HUNTER INDOOR SPORTS CENTRE (SSD-65595459) - 24 WALLARAH ROAD & 2 MONASH ROAD NEW LAMBTON

I refer to the Department of Planning, Housing and Infrastructure's (DPHI) request of 14 October 2024 via the NSW Major Projects Portal inviting City of Newcastle (CN) to provide advice on the development mentioned above. I also refer to CN's letter of 11 November 2024 which provided preliminary advice.

The exhibited Environmental Impact Statement (EIS) and architectural plans have been reviewed by CN officers and the following advice is forwarded for your consideration. We recommend the Applicant (Basketball Association of Newcastle Limited) is required to respond to those matters, where indicated:

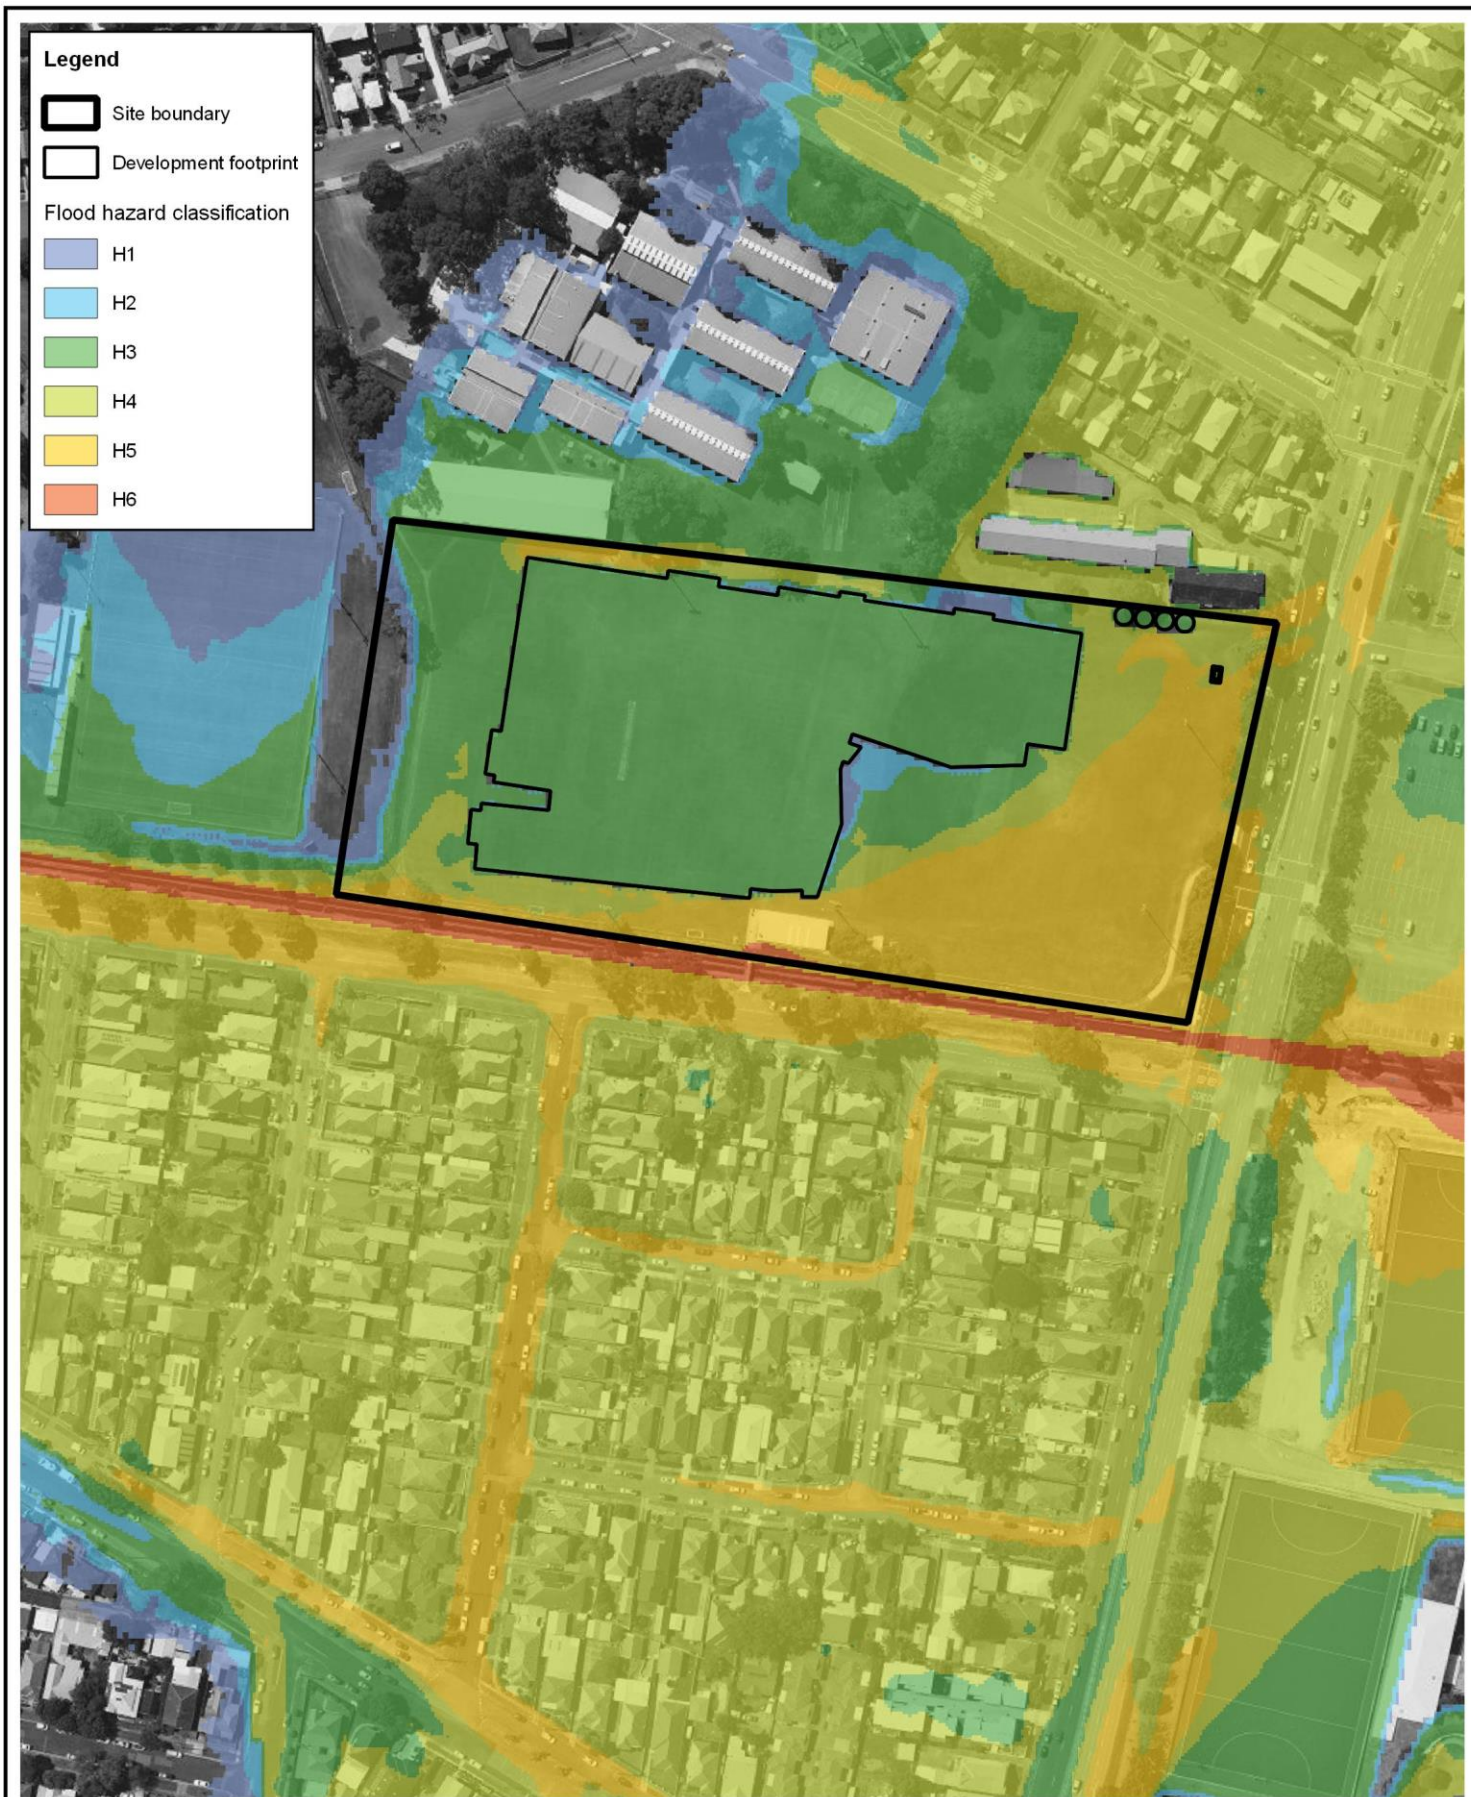
- e. *Proposed car parking in high flood hazard areas* - Figures 5-5 and 5-6 of the FIRA indicate peak flood hazards in post-development conditions for the 10% AEP and 1% AEP 2050 flood events, respectively. CN notes the carparking areas of stages 1B and 2 and parts of 1A are affected by flooding at a hazard level of H2 and H3 during these events. In accordance with Control 8.0(C-7), CN does not generally consider carparking facilities to be suitable in areas subject to flood hazards greater than H1.

It is also noted that at the modelled 10% AEP event, a high number of car parking spaces are affected by H3 and H2 flood hazards. Considering the intermediate frequency of the 10% AEP, CN is concerned the parking of vehicles in these areas will result in flood risks to property (including private vehicles).

The proposed car parking areas in the front setback of the development (Stage 1B and Stage 2 carparking areas) are not compatible with the flood hazard of the land. CN recommends that the development be revised such that no carparking facilities are provided in these areas and these areas remain usable open space.

- i. Redesign or provision of additional fill such that the Stage 1A car park is not exposed to flood hazards greater than H1 during the modelled 1% AEP 2050 flood event. Any additional filling will need to be supported by revised flood modelling.

5-10

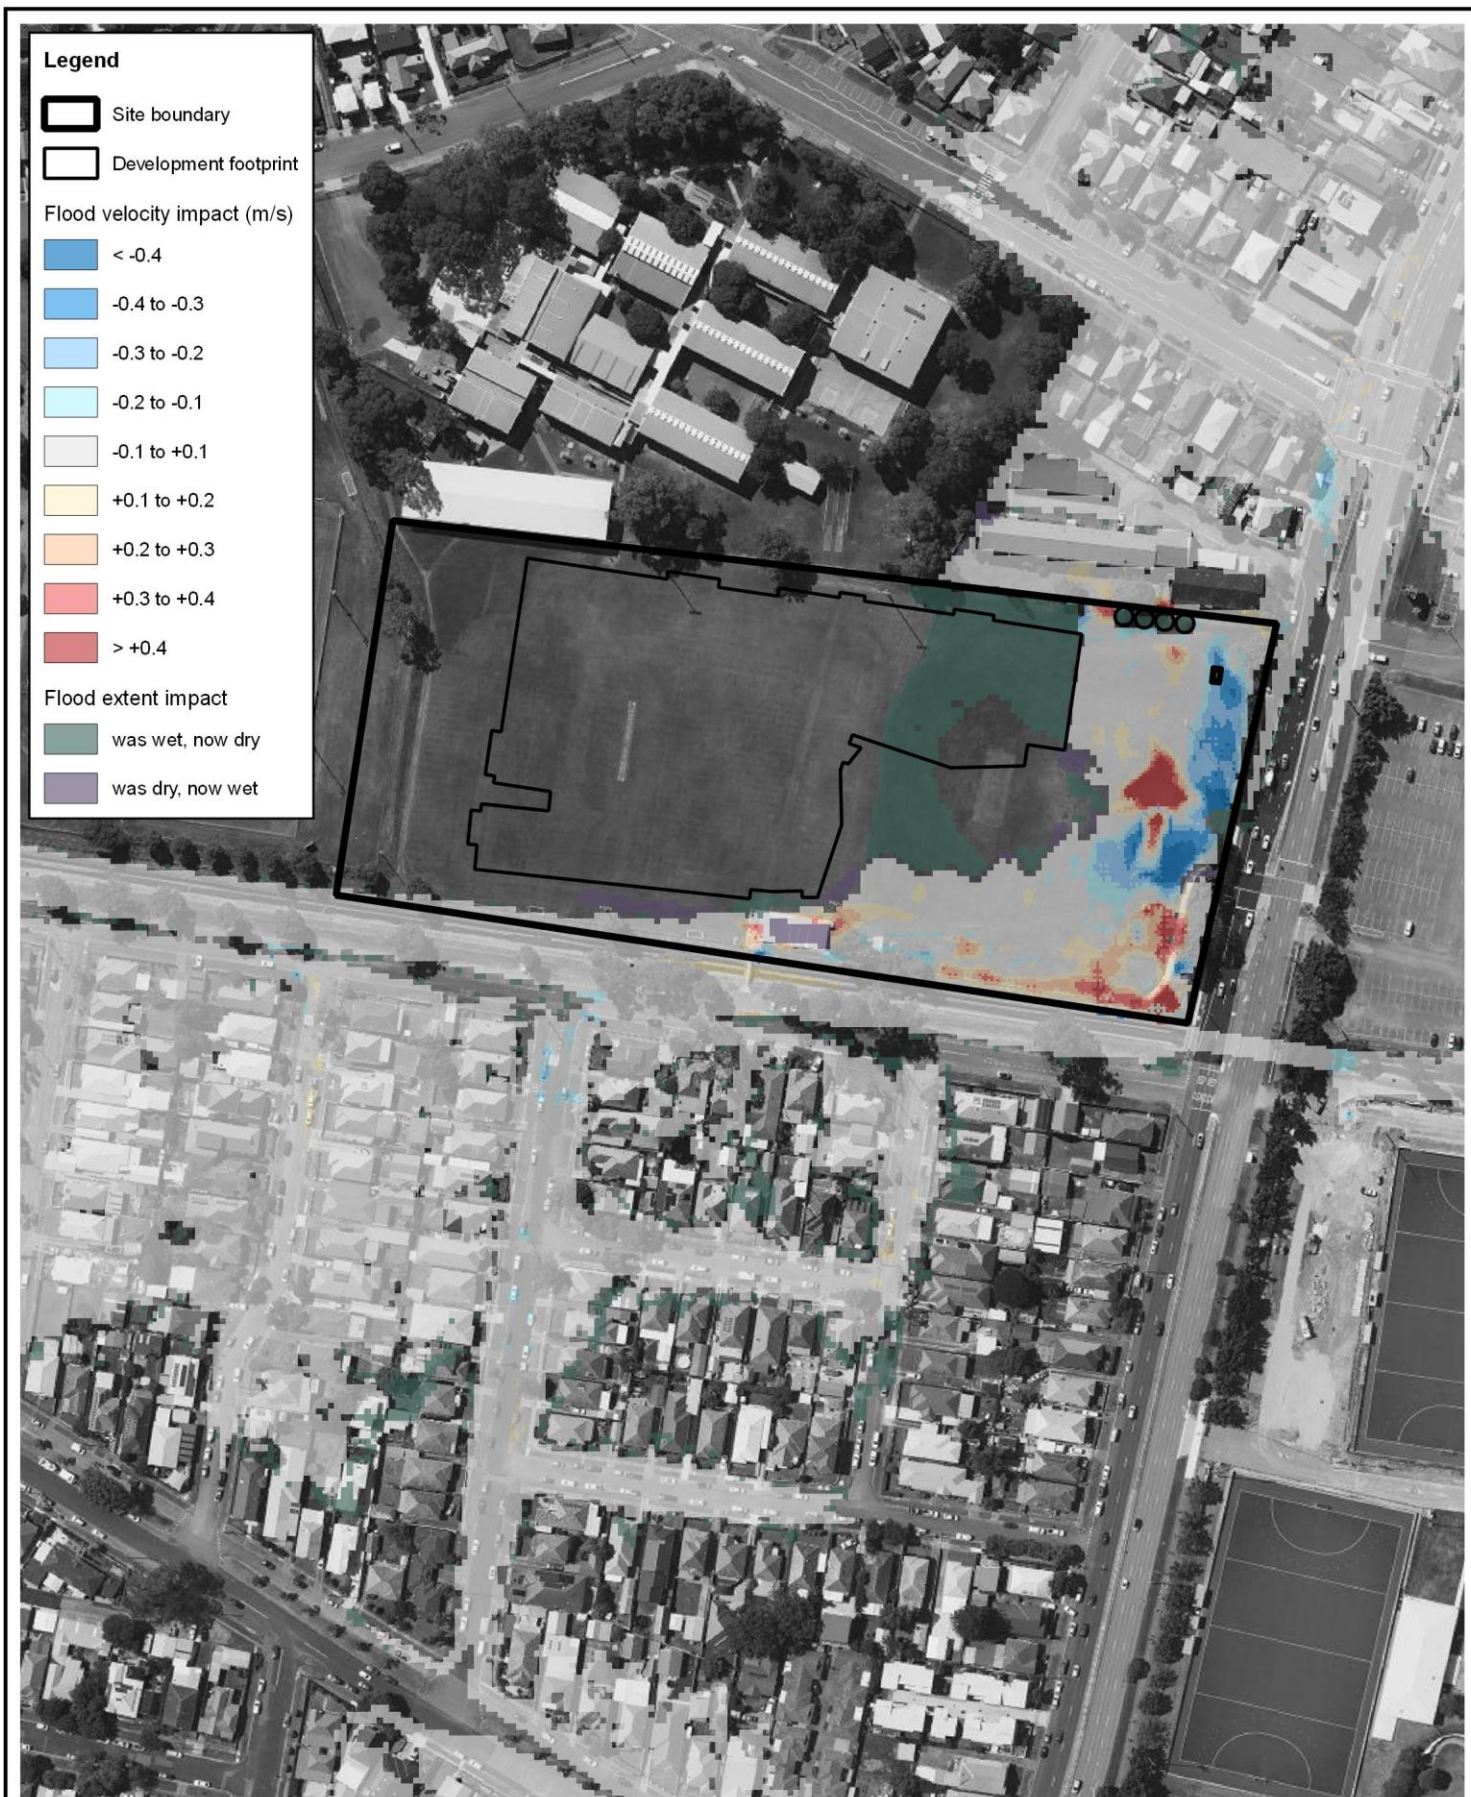
CN does not support the proposed impact on peak flood levels during the PMF event at the scale and magnitude indicated in Figure 5-10 of the FIRA.

Increases to peak velocities and/or peak flood levels can undermine the effectiveness of any existing flood refuges. For this reason, CN raises concern regarding the modelled impact on peak flood levels and velocities at the PMF as documented in the FIRA.

CN recommends the Applicant be required to revise the design of the development to achieve modelled flood level impacts not exceeding +0.05 metres at the PMF event.

5-11

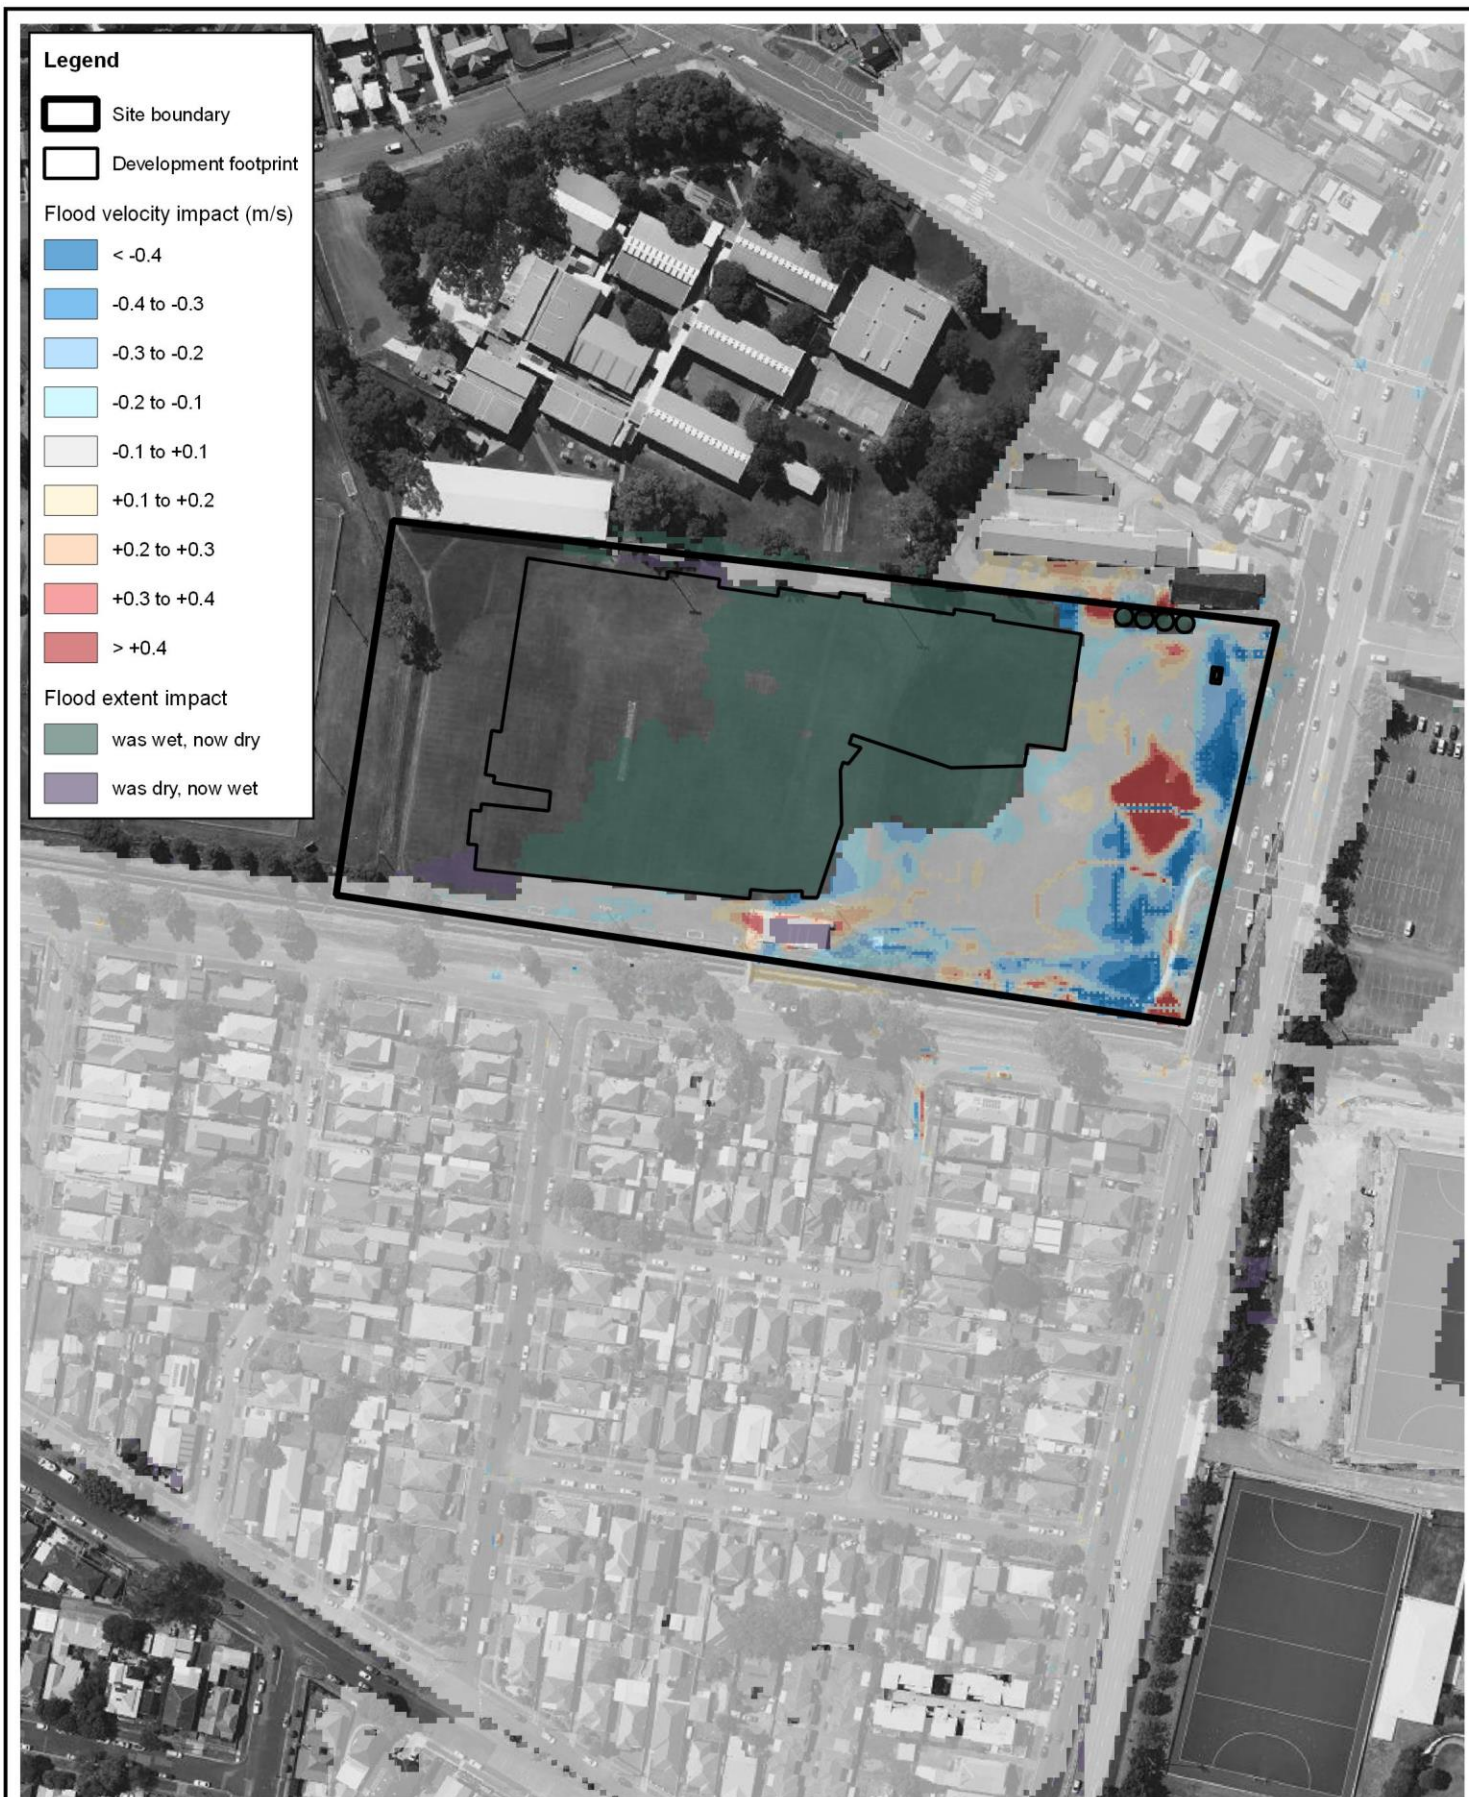
- b. *Mapping pre- and post-development peak flood velocities* - Figures 5-11 to 5-13 in the FIRA highlight development impacts on flood velocities during the modelled events but no mapping was provided for velocities in the pre- and post-development scenarios.

- d. *Peak flood velocity impacts* - Figures 5-11 to 5-13 of the FIRA present modelled numerical impacts on peak flood velocities (i.e. in terms of m/s). CN recommends additional mapping is provided presenting the impacts of the development on peak flood velocities as a percentage increase/decrease from modelled pre-development velocities to allow assessment of these impacts against starting-point limits set out in Department of Planning and Environment's publication 'Flood Risk Management Manual'(2023).

CN recommends that additional mapping is prepared illustrating pre- and post-development peak flood velocities for all modelled flood events to better inform how the proposal may change flooding in the area.
